Subject: Response to Submissions – Aussie Skips Recycling - Bellfrog St Site upgrades (SSD-67497708)

CPHR advice on RTS - Aussie Skips Recycling - Bellfrog St Site upgrades located at 13 Bellfrog Street, Greenacre.

Figure 4 GGBF Habitat Concept Landscape Design Layout

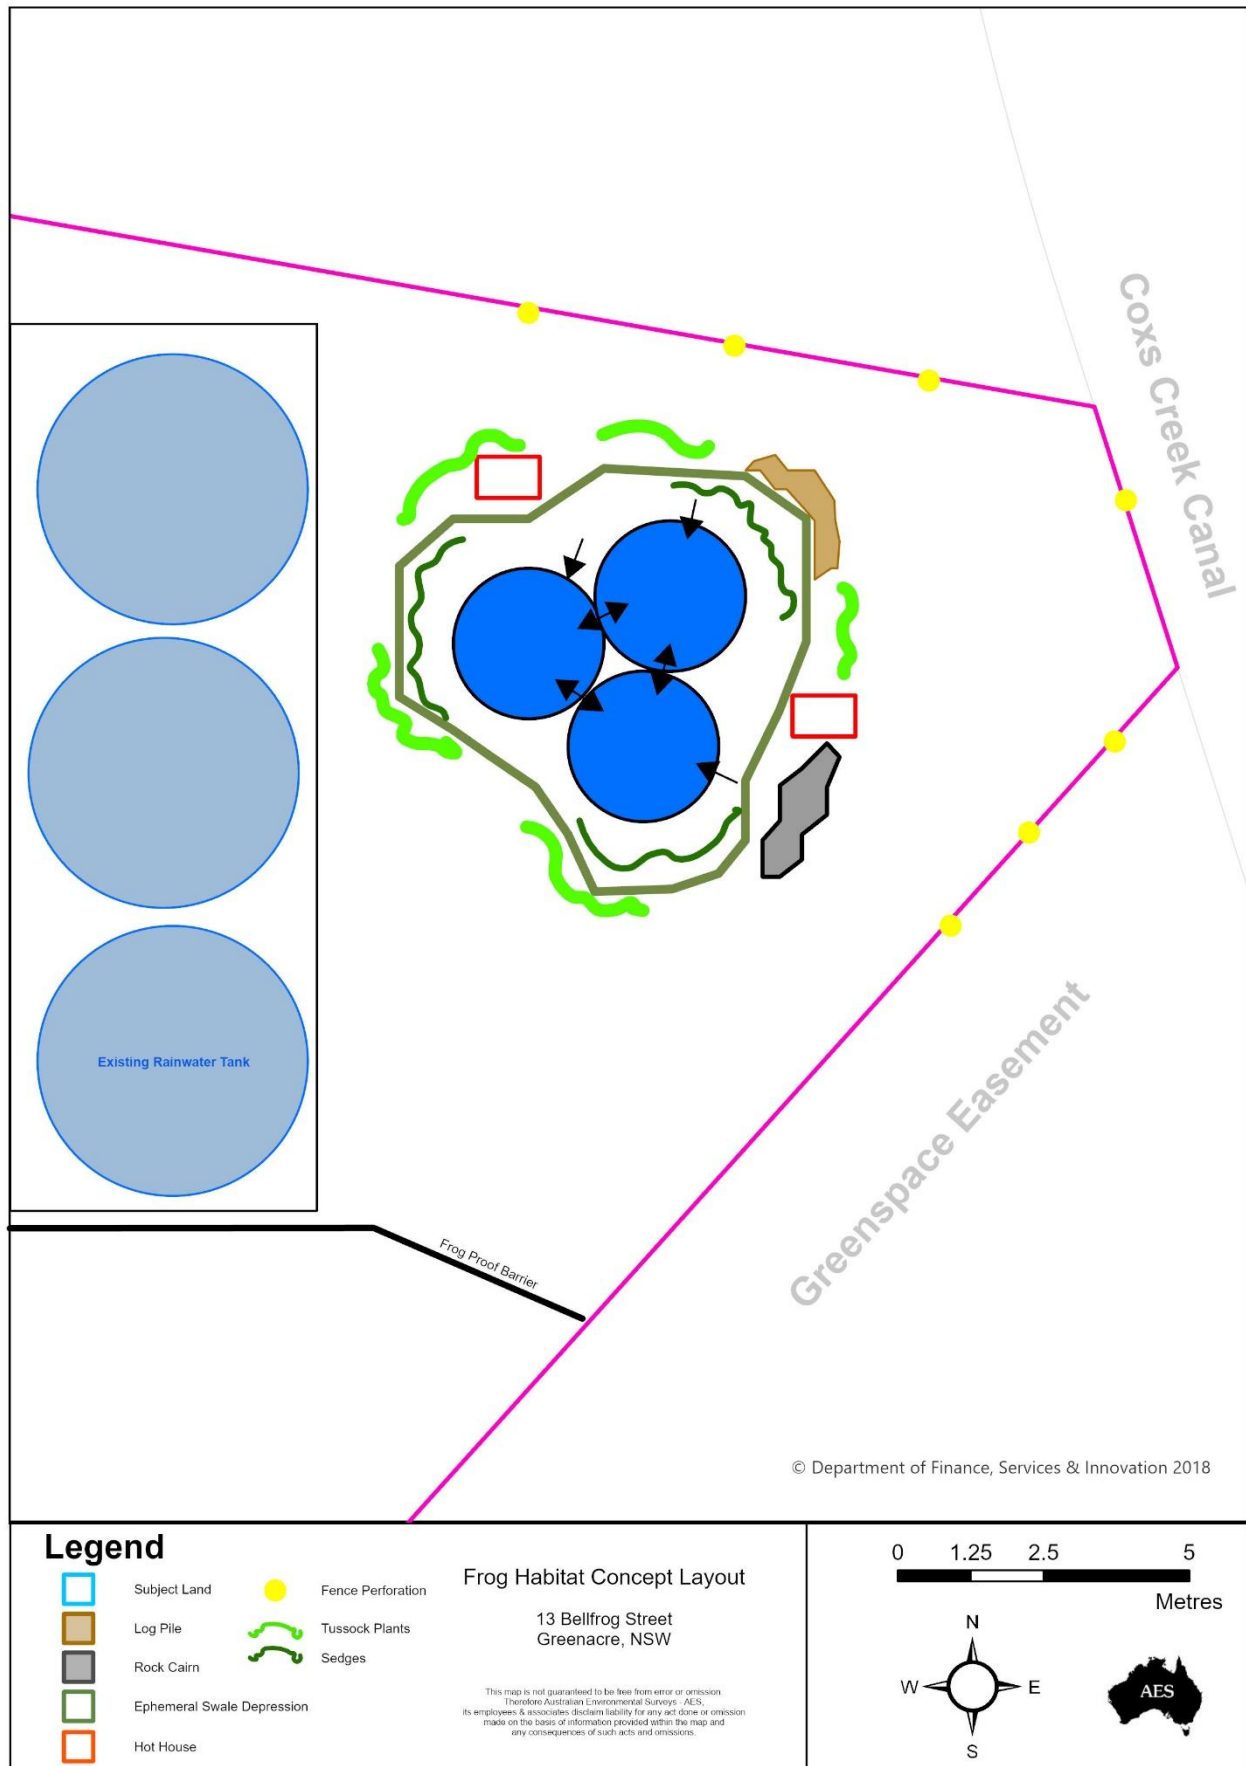
- Revise all Green and Golden Bell Frog (GGBF) mitigation measures so they are expressed as clear, enforceable specifications rather than recommendations or options.

- Certification / sign-off.
- Include a requirement that the creation of habitat and installation of frog fencing be supervised and certified by a suitably qualified ecologist, with all such works completed prior to the commencement of construction.

- Update Section 4.2 of Appendix A to include detailed and specific measures to prevent light spill and light pollution impacts on the identified conservation area.

- Include a mitigation measure that clearly sets out vegetation management requirements, noting that mowing and similar activities have the potential to injure GGBF individuals that may utilise the site.
